REQUEST

Current Zoning: CC, LWPA (commercial center, Lake Wylie Protected Area)
Proposed Zoning: CC SPA, LWPA (commercial center site plan amendment, Lake Wylie Protected Area)

The petition proposes to amend petition 2008-125 to allow the development of up to 336 apartments on vacant land.

RZ-1.0

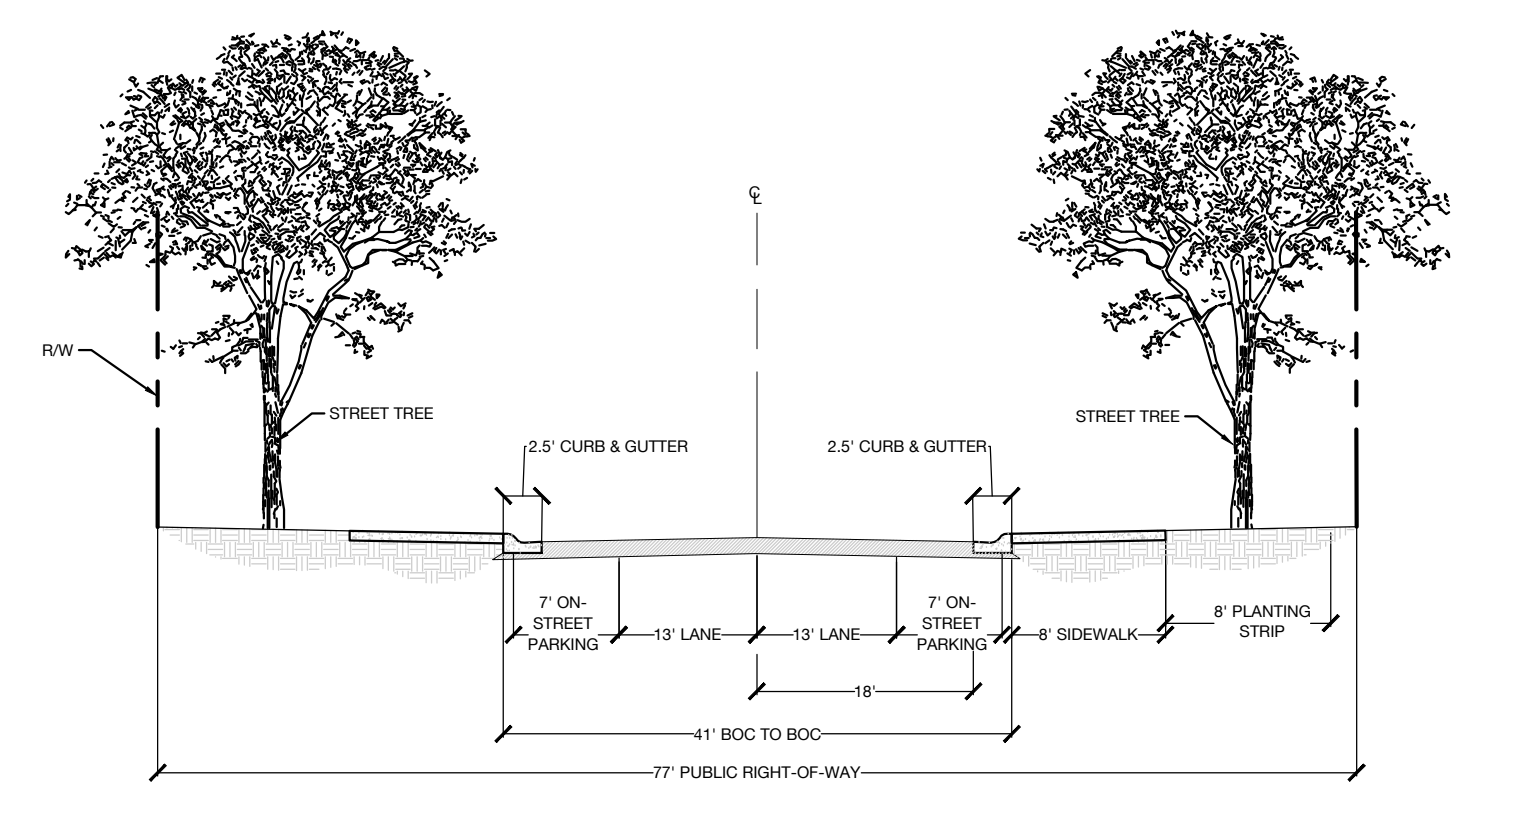
1. ~~Revise building locations to be in compliance with setbacks as stated in Section 9.303(19)(e).~~ **ADDRESSED**
2. ~~Revise building orientation to limit the number of side facing buildings as they relate to the Public Road 1.~~ **ADDRESSED**
3. ~~Revise Architectural and Design Standards note 4.b to replace the word "or" with "and" and "may" with "shall" as specified in the site plan comments.~~ **ADDRESSED**
4. ~~Revise the rear yard from 25' to 40' as specified in site plan comments.~~ **ADDRESSED**
